City of Albuquerque

RE: REVISED DRAINAGE PLAN FOR HIGH STREET APARTMENTS
(K-14/D37) REVISION DATE OF NOVEMBER 3, 1987

**GRADING AND DRAINAGE PLAN
HIGH STREET APARTMENTS**

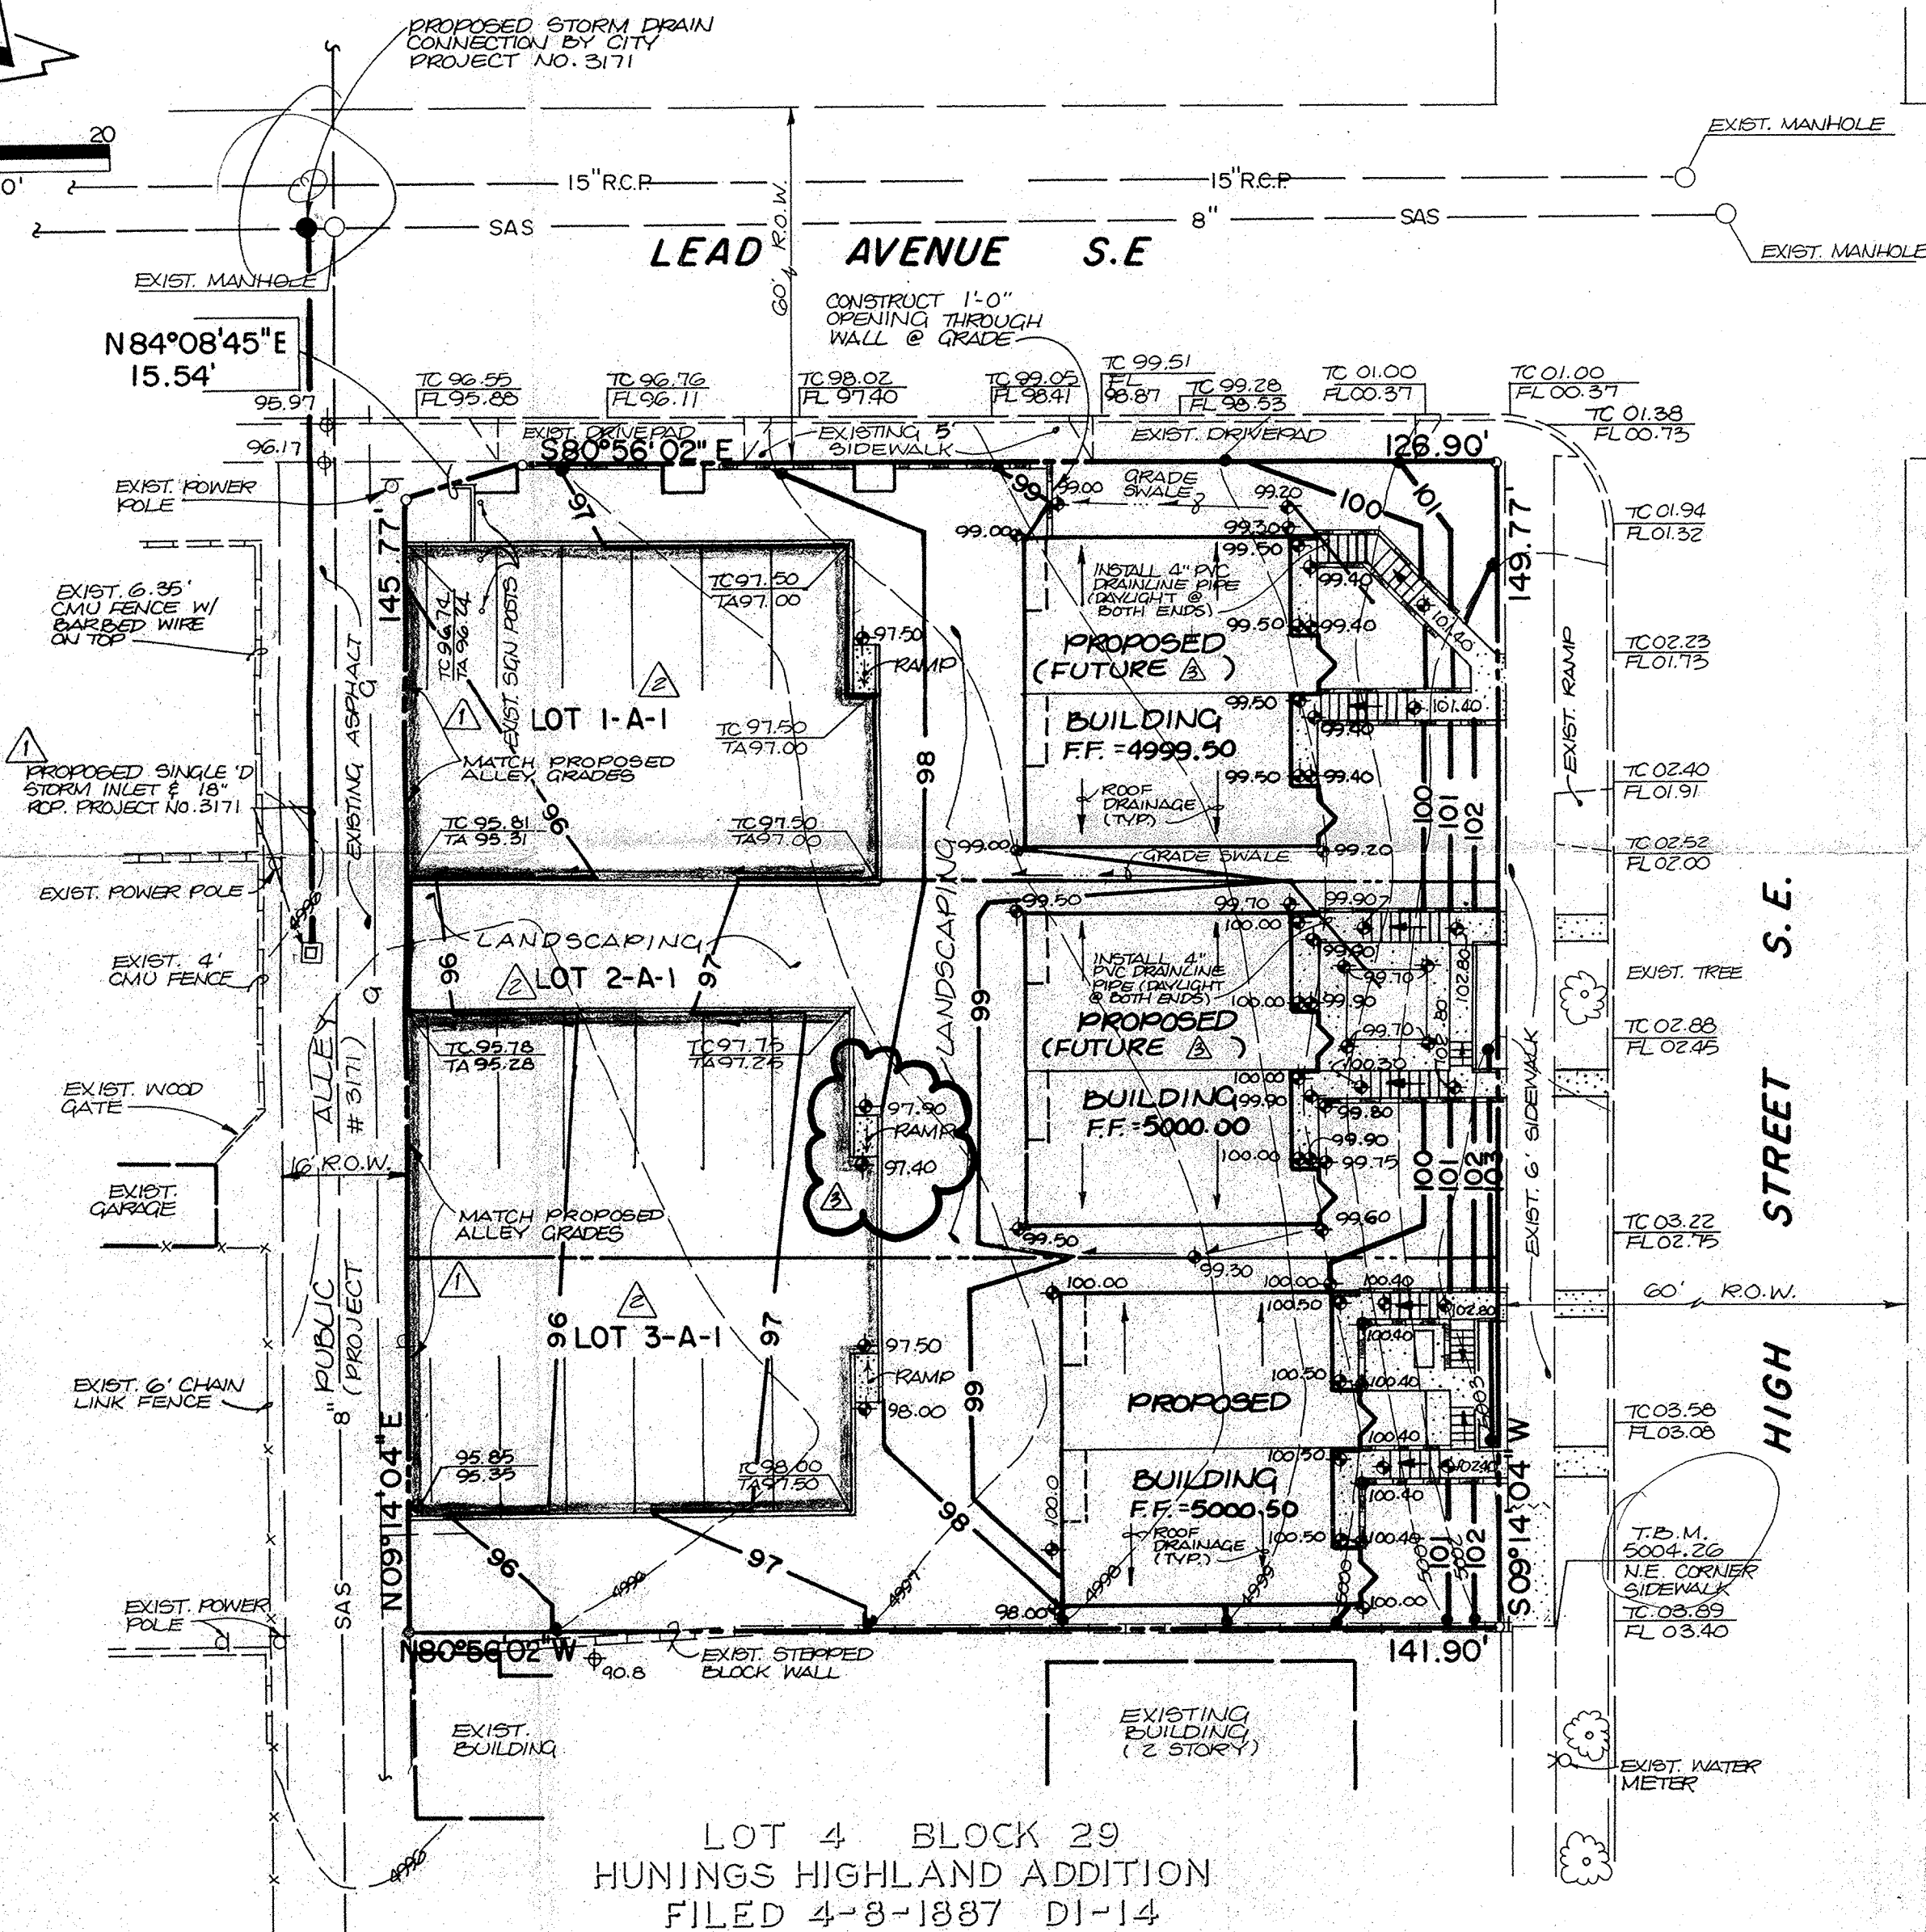
We are in receipt of your revised drainage plan indicating the new lot lines. Please be advised that the replat will need to indicate provisions for cross-lot-line drainage.
